**One Carrington Street - SSD 5824 MOD 8**

Amending roof level at 285 George Street

Demolition Plan - 285 George Street

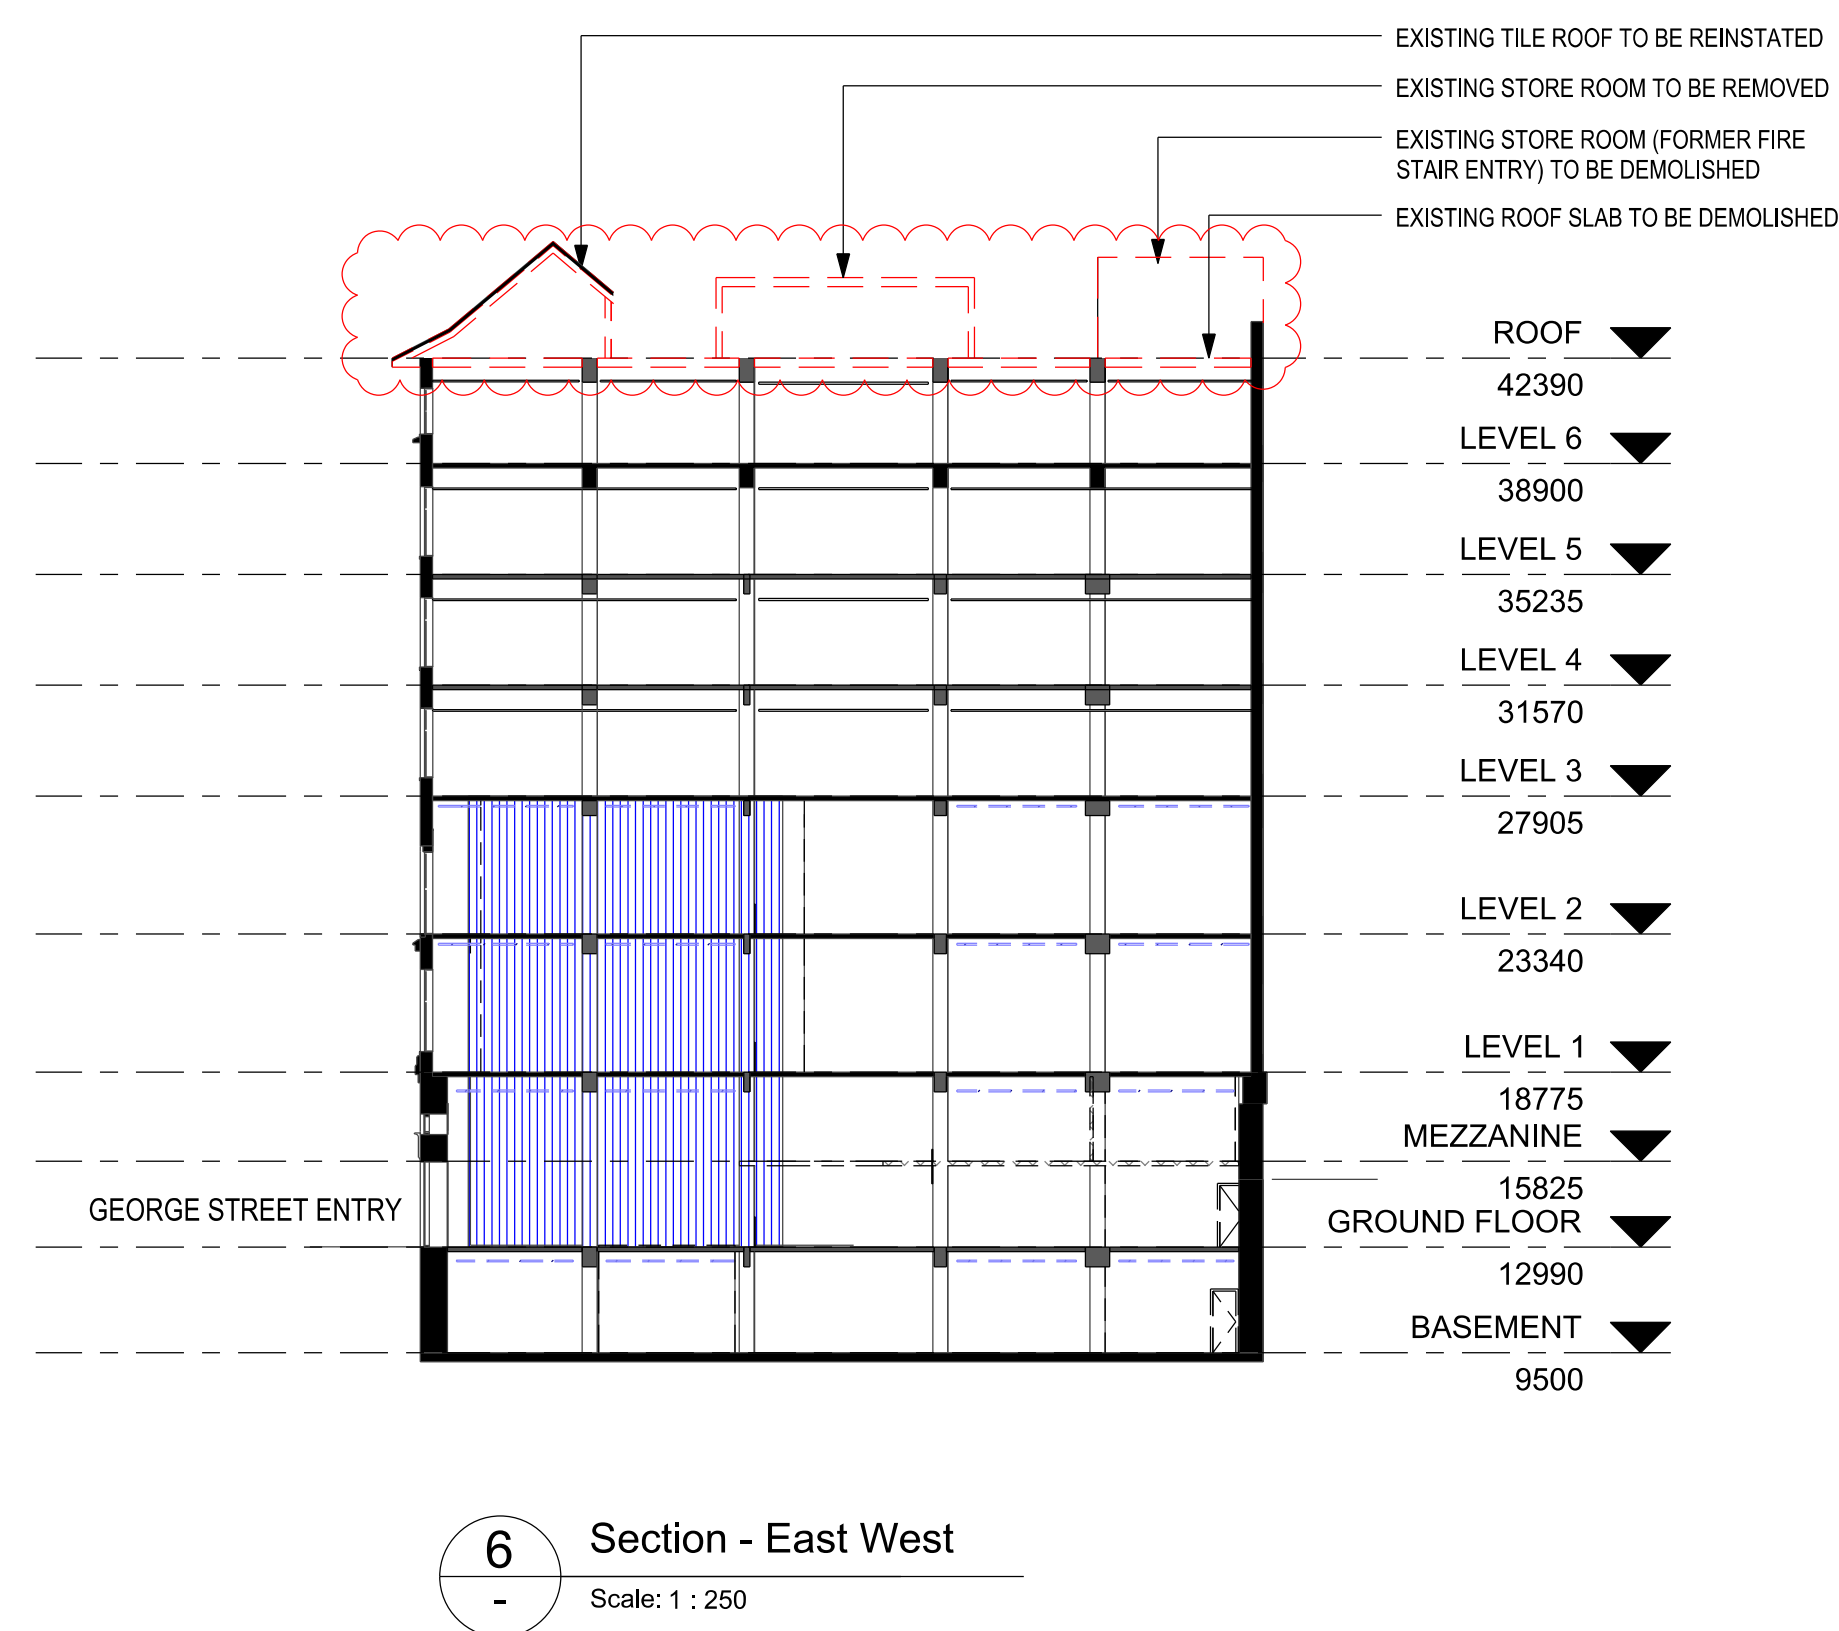
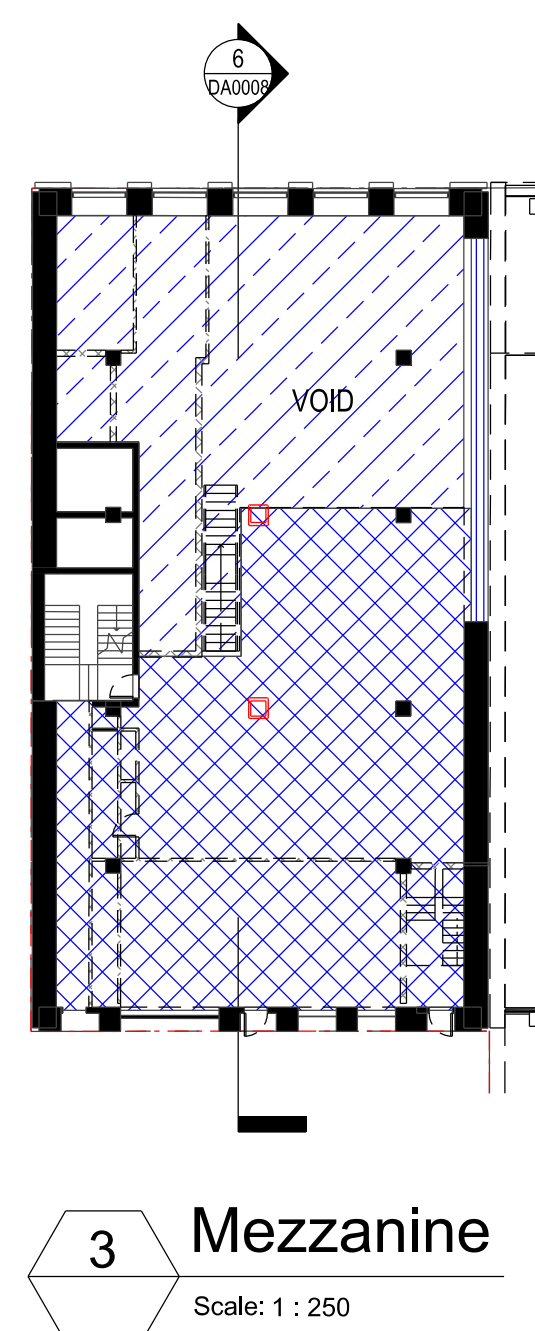
The submitted heritage assessment prepared by GML Heritage recommends that a structural detail and construction methodology regarding demolition and construction of the new steel roof should both be prepared to avoid or minimise risk to significant fabric of the building. The City recommends that these details be provided as part of this assessment to ensure the protection of the heritage significance of the building and in particular the existing cornice is achievable. City staff can be consulted in finalising these methodology statements.
